McDonald's Old Town MRP
Variance Option 1
Rec'd. 12/31/13

PLAN APPROVALS		
SIGNATURE (2 REQUIRED)	DATE	
REGIONAL MGR.		
CONST. MGR.		
OPERATIONS DEPT.		
REAL ESTATE DEPT.		
CONTRACTOR	OWNER	
CO-SIGN SIGNATURE		
STATUS	DATE	BY
DATE DRAWN	5/27/14	ASD
PLAN CHECKED	5/27/14	MAM
ASBUILT		
SHEET NO.		
SP-1

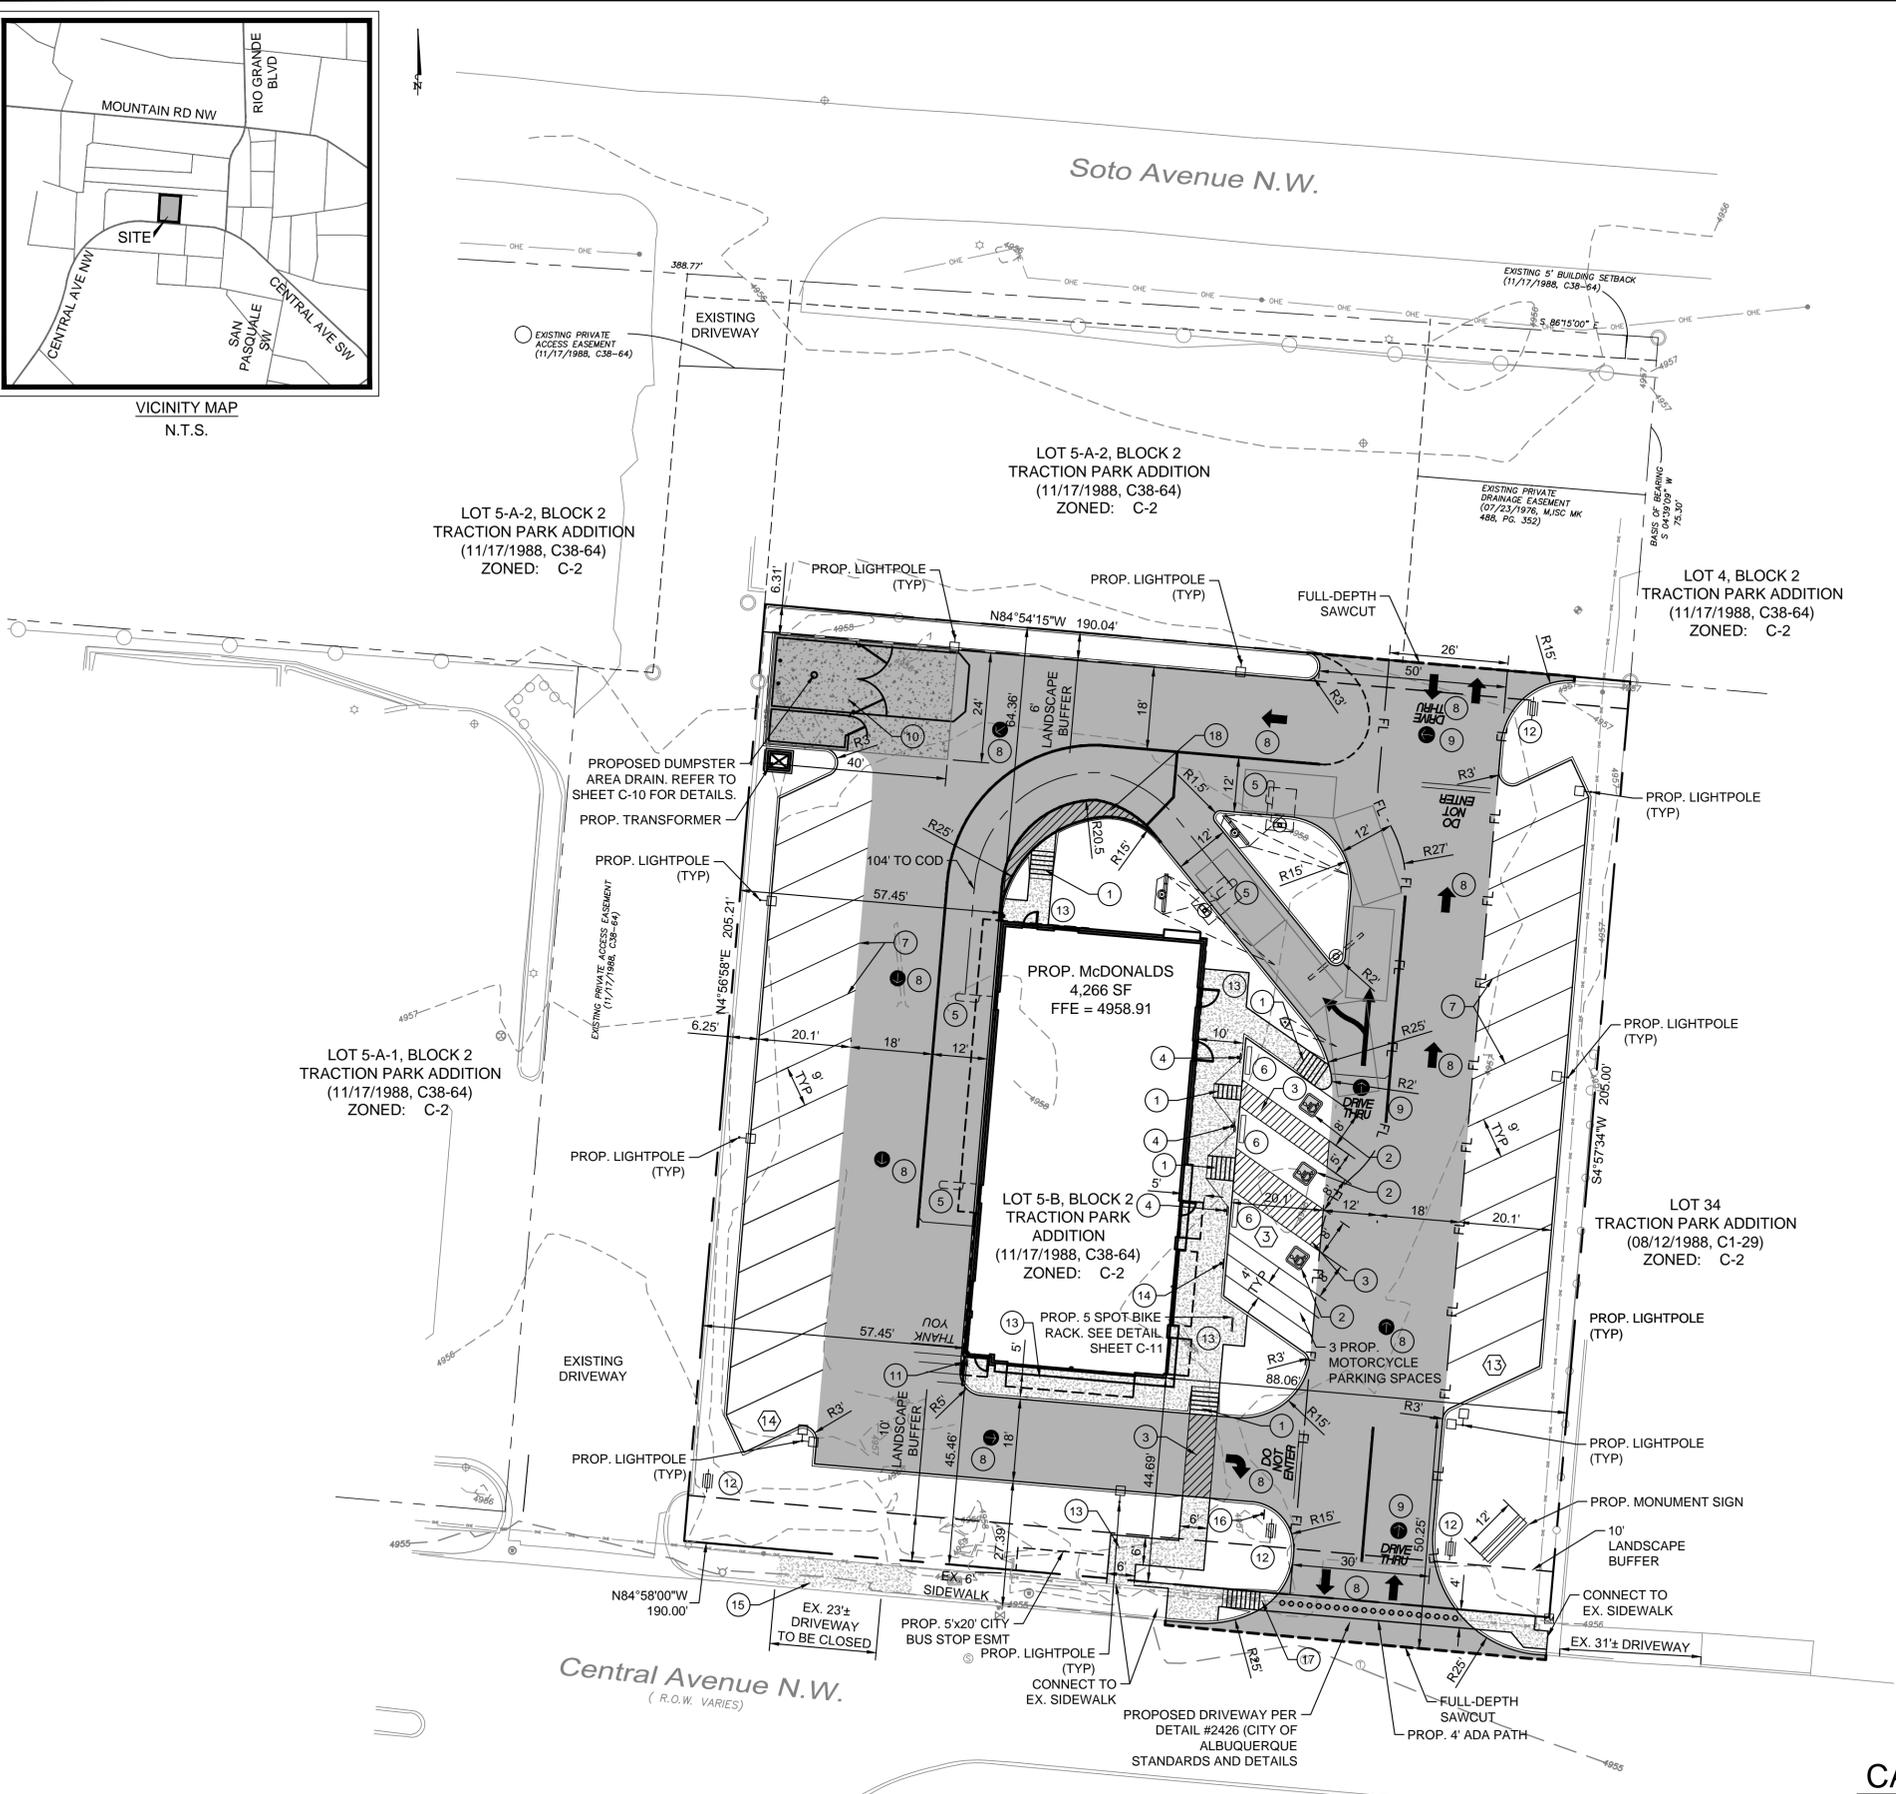
Suggest
relocating
further east
conflicts

Show heavy vehicle
pathway deliveries?
to justify R20

Conflict
Turn/U-turn: hard to maneuver
- too close to street
- hazard for pedestrians
- driver cannot see - position of angle
- vehicle pathway difficult
- Show template.
